CITY OF ALBUQUERQUE

February 24, 2025

**RE: 8609 Mesa Rain Rd NW
Grading and Drainage Plan
Engineer's Stamp Date: 1/29/25
Hydrology File: H09D017A3**

ENGINEER'S SEAL  3/3/25 1/29/25 DAVID SOULE P.E. #14522	LOT 52 WATERSHED SUB. 8609 MESA RAIN ROAD GRADING AND DRAINAGE PLAN  P.O. BOX 53924 ALBUQUERQUE, NM 87199 (505) 321-9099	DRAWN BY DEM DATE 1-29-25 8609 Mesa Rain Lowered .dwg SHEET # C1 JOB #

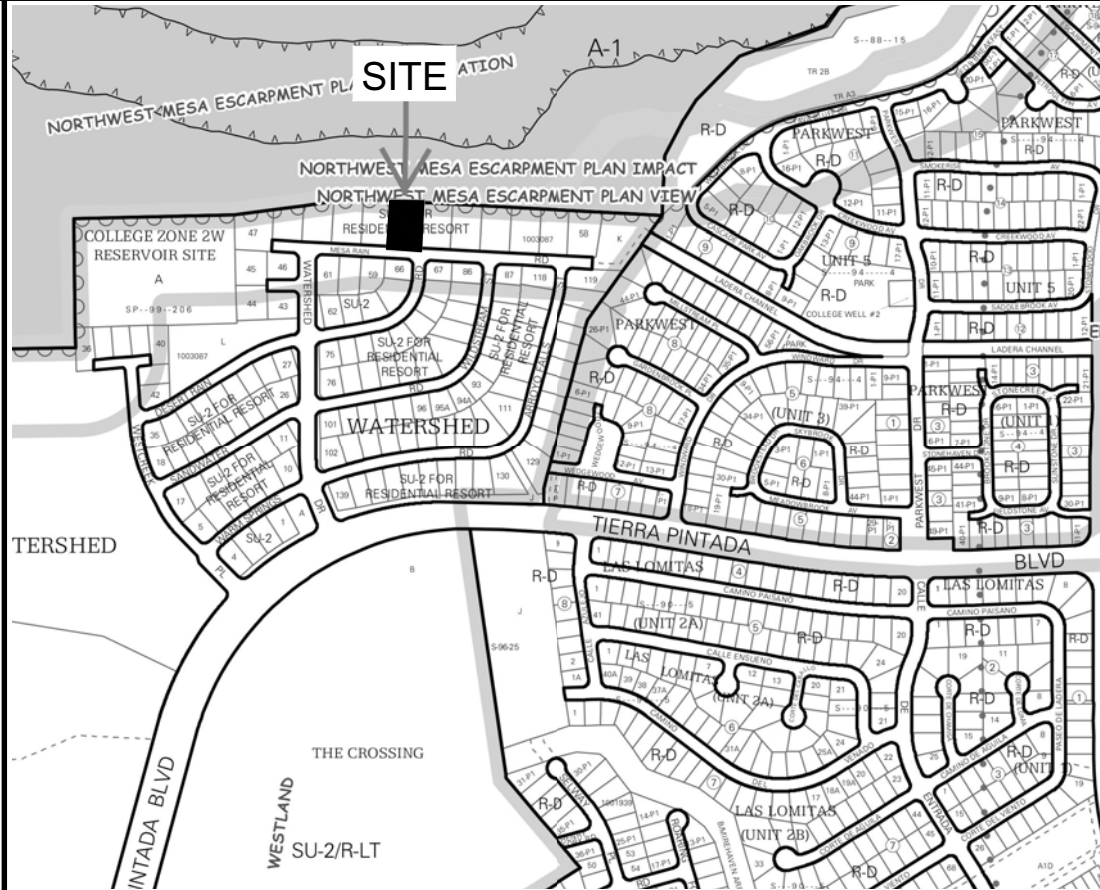
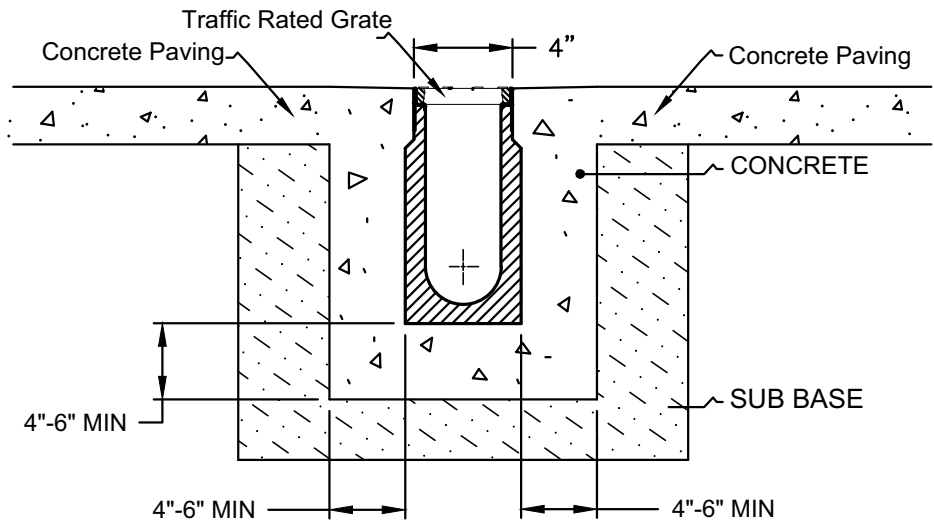
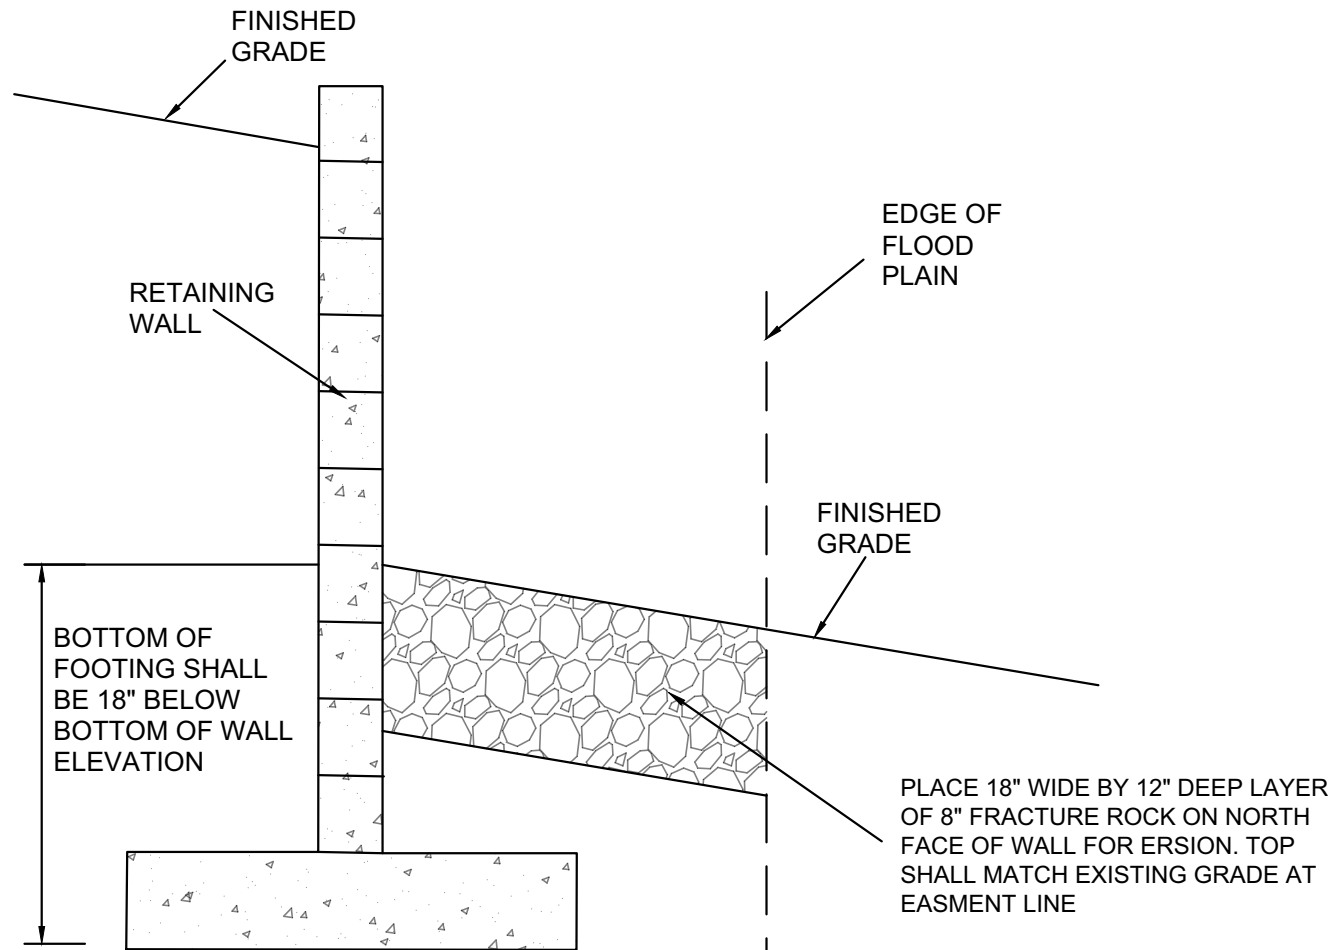
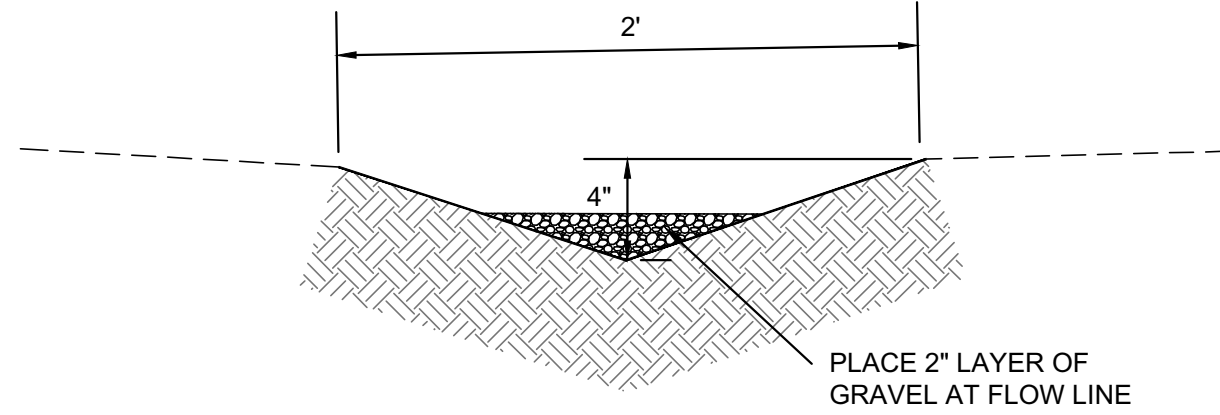
1. A portion of this project is located in a floodplain (AO-1') and a floodplain development permit must be obtained. The permit application must demonstrate zero rise to the base flood elevation, unless a Letter of Map Revision (LOMR) is being prepared. Please contact Rudy Rael, CFM for more information regarding floodplain development permits (rrael@cabq.gov or 924-3977).

2. Due to the Floodplain Development Permit, Elevation Certificates based on the Construction Drawings (and Finished Construction prior to CO) will be required.

3. Please add a note in the cross sections, "Floodproof the retaining wall below the 100-year 10-day volume water surface elevation per the City's specifications."

4. Show the distances of the scour wall to the north property line.
5. Include the project Benchmark used.
6. Show the spillway crest location and elevation, the spillway flow depth, and the dam top elevation.
